From: Philip Woolger [REDACTED]
Sent: 27 October 2020 12:34
To: Kathryn Welch <Kathryn.Welch@arun.gov.uk>
Subject: RE: 8 Fernhurst gardens.

From: "Kathryn Welch" <Kathryn.Welch@arun.gov.uk>
To: "Philip Woolger" [REDACTED]
Sent: Tuesday, 27 Oct, 20 At 10:51
Subject: RE: 8 Fernhurst gardens.

Re-place existing sun room with purpose built ground floor extension with pitched tiled roof.
Double glazed windows and doors

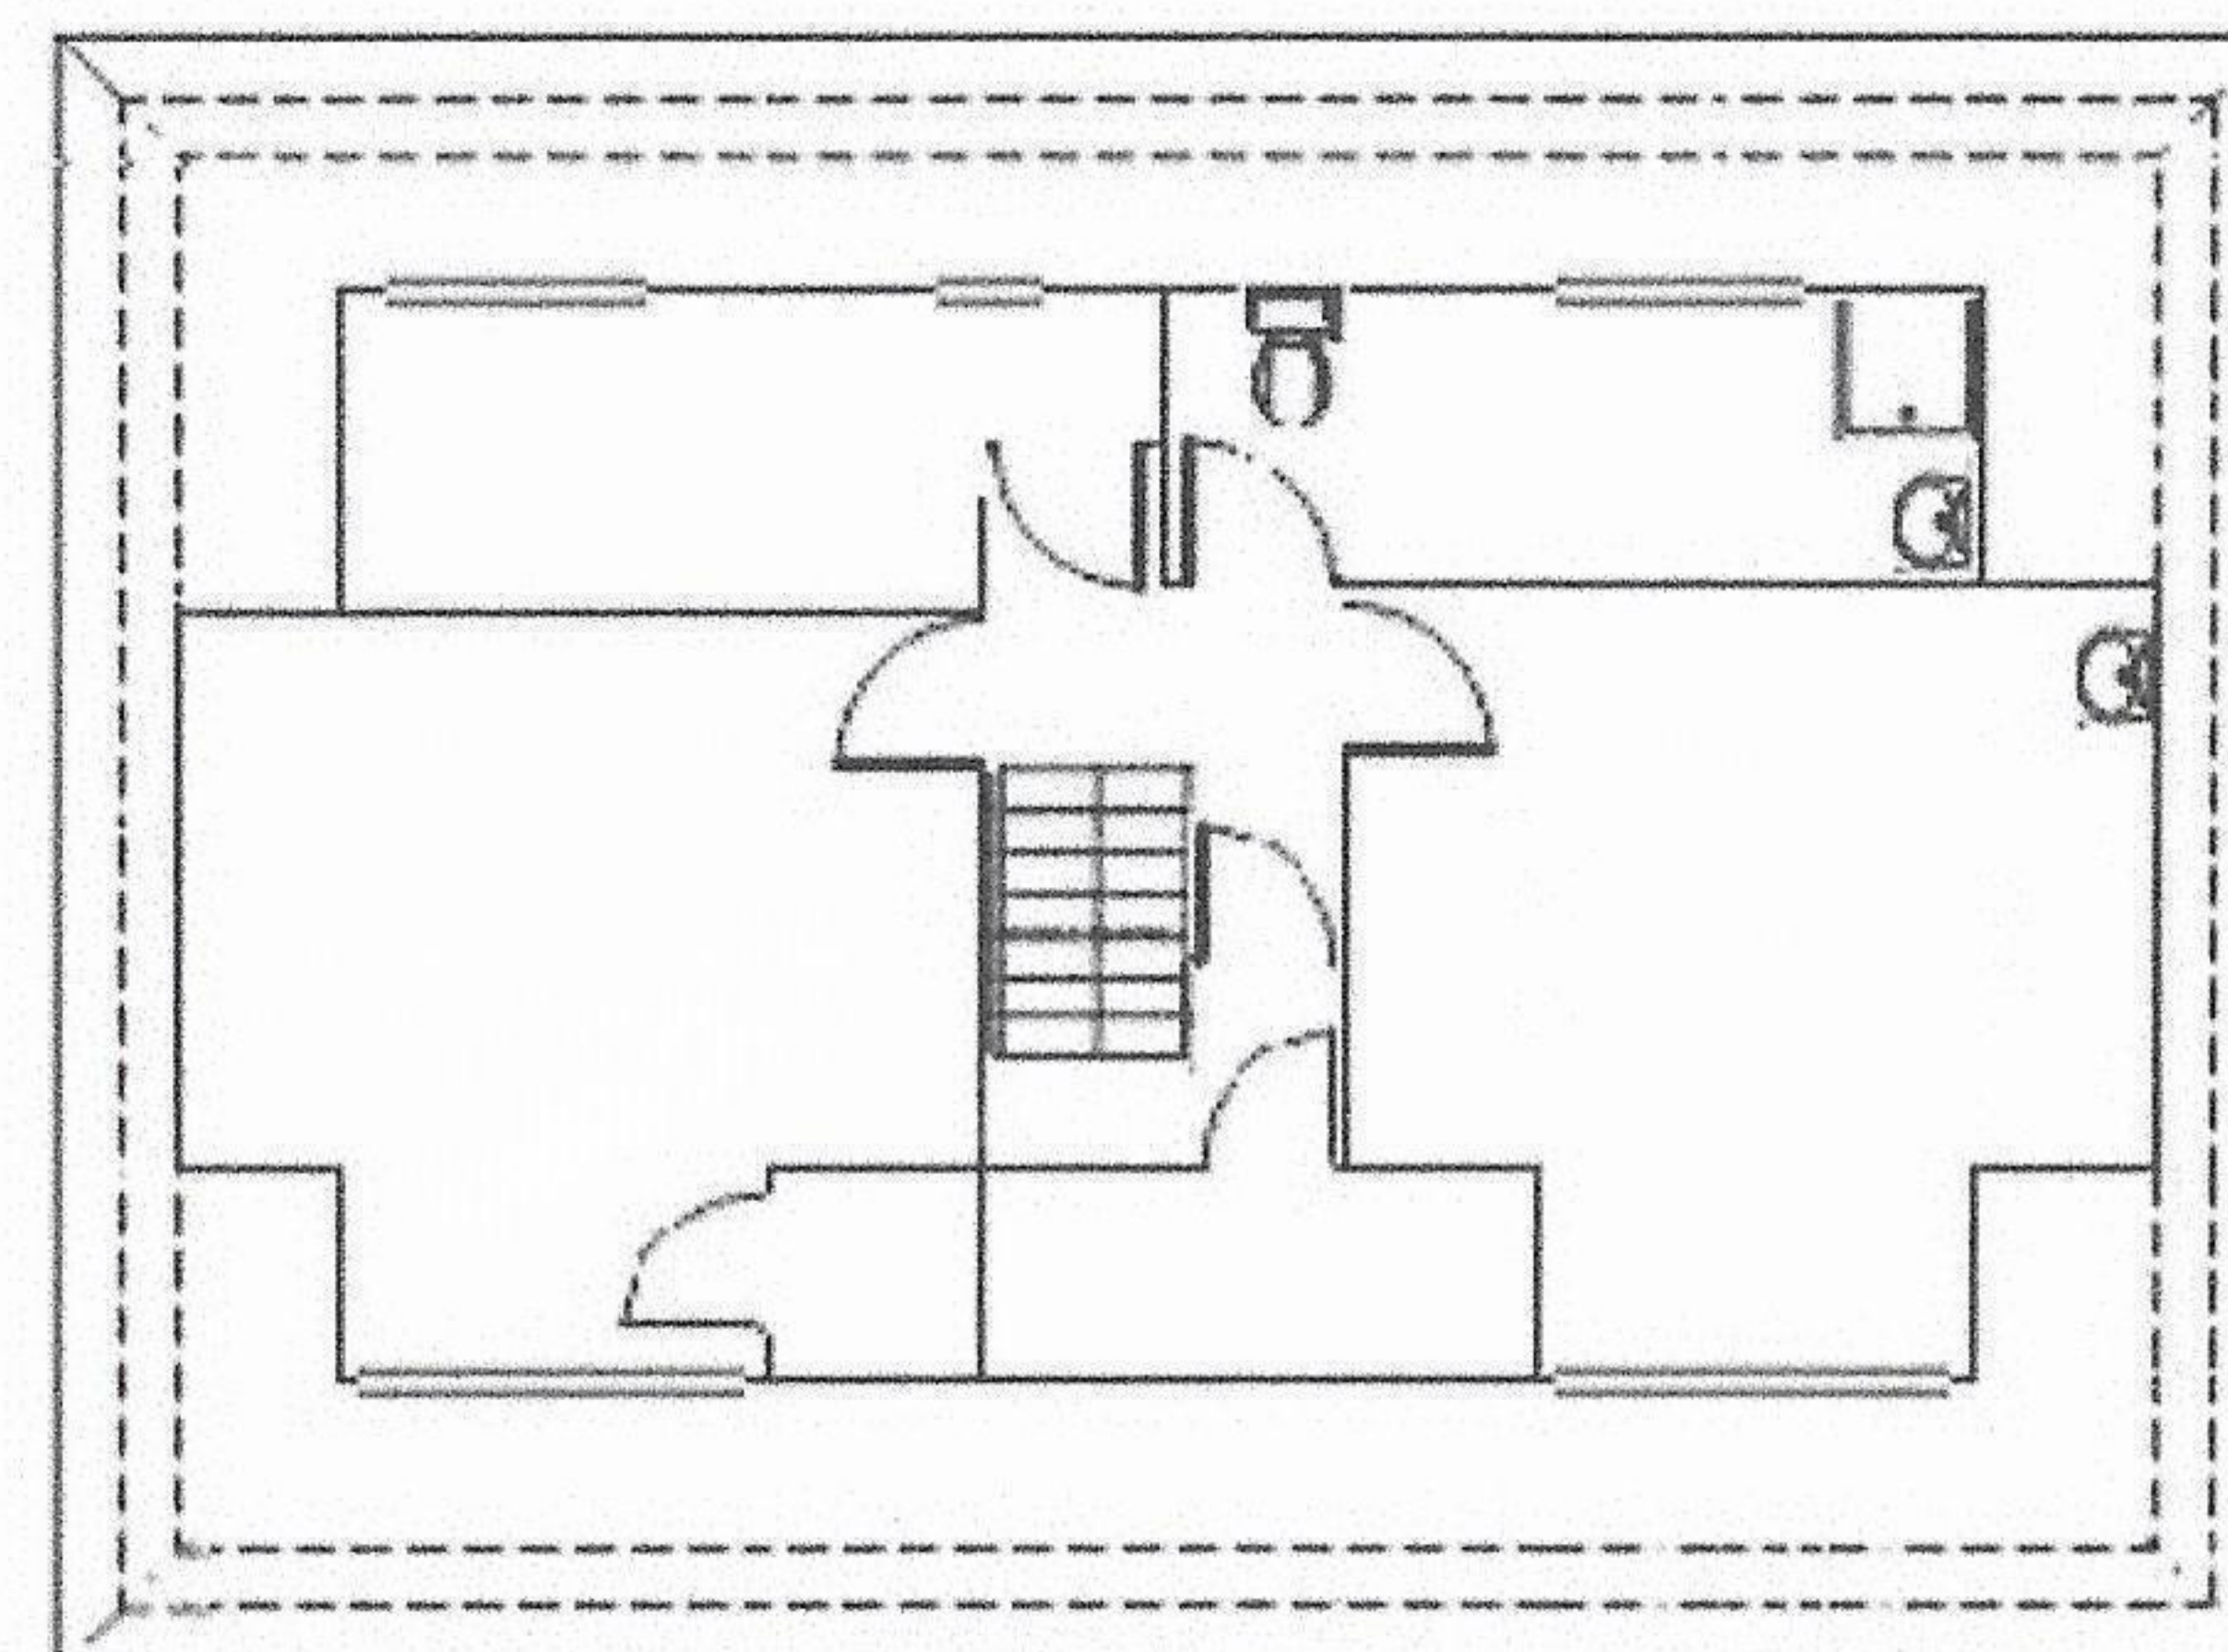
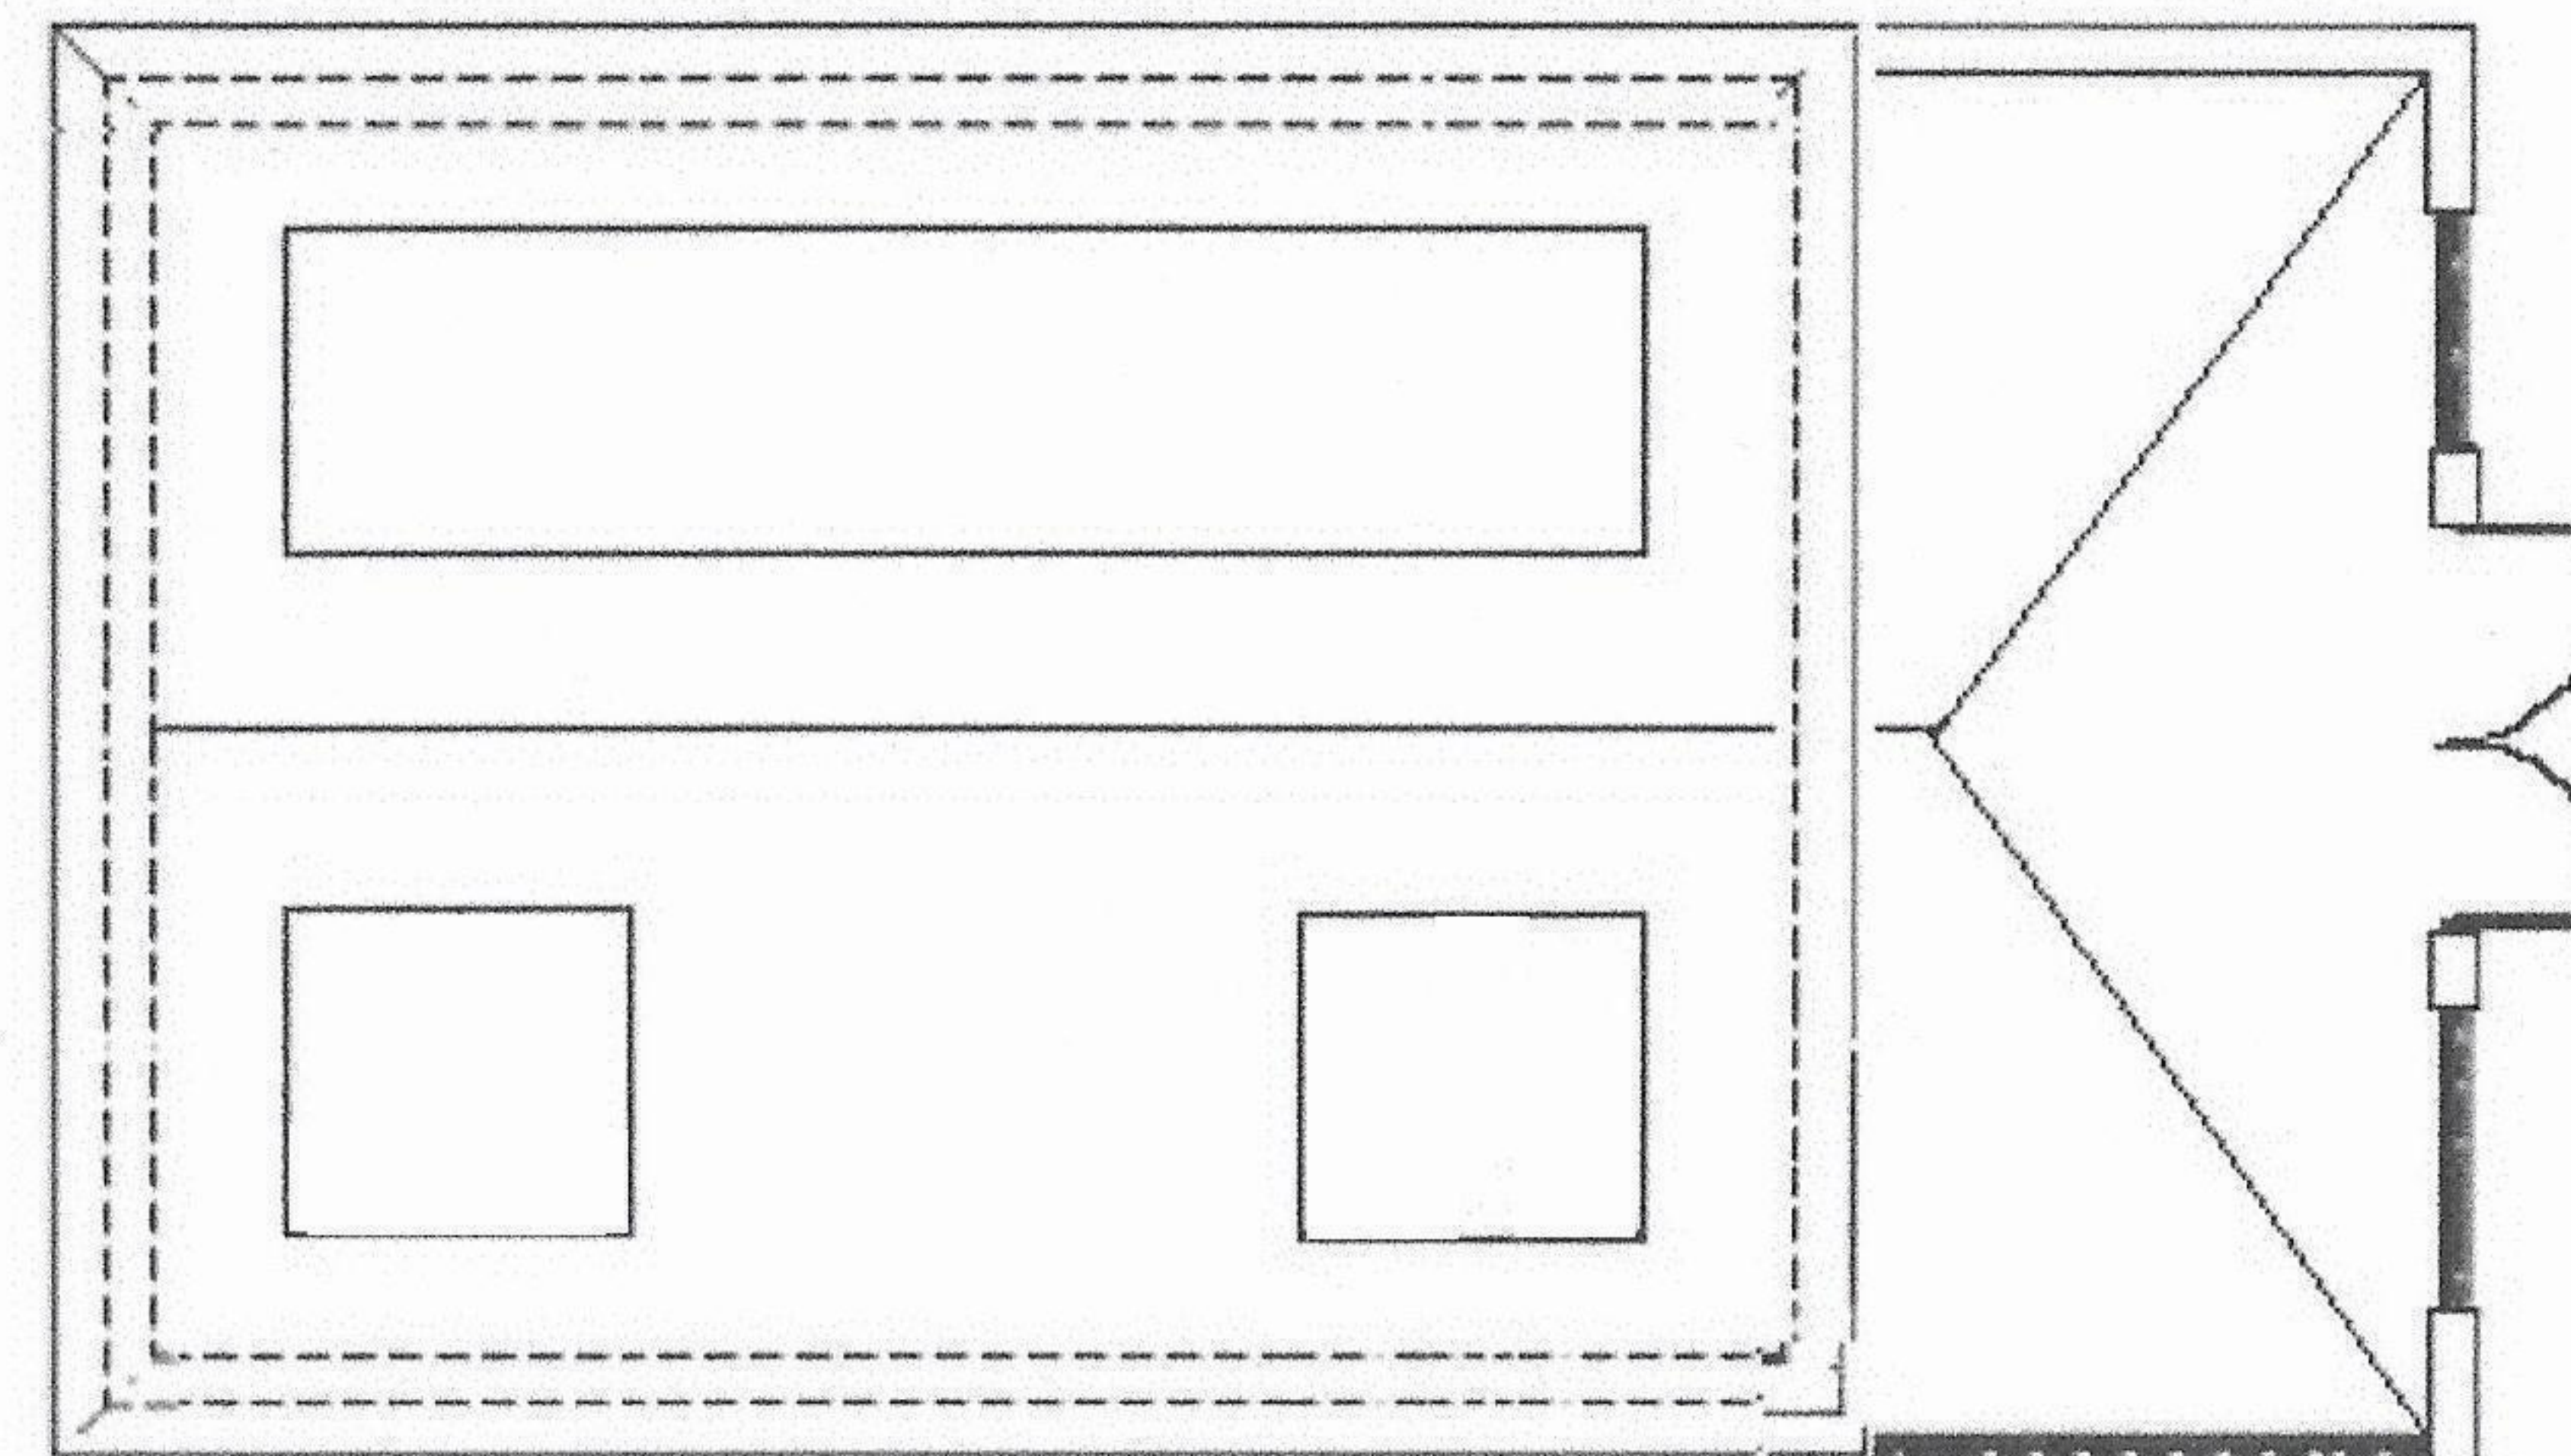
- The porch is slightly too large, to be covered by PD rights the maximum allowance is 3m² and your proposal currently measures at 3.84m² can you adjust this on plans 010 and 003.
- Can I have confirmation of the height to the eaves for the extension, either via email or included within a plan,
- Can you confirm that the extensions will be built of materials to match the existing property. You've noted a concrete slate tile on the roof of the extension; do you already have these on the existing house or can you amend to something similar to the existing,
- Can you confirm the proposed hardstanding for 2-3 cars will be built of either porous materials or will drain off to water permeable area within the site, again just a written confirmation will suffice.

porch 3m x 1m ...2.2m to eaves.....Antique red Marley plain tile 265 x 165mm as per existing building.....and Block paved driveway (we were planning on this)just missed it off. We understand about the drain off on solid concrete.

Attached drawing 003...and 010...adjusted .
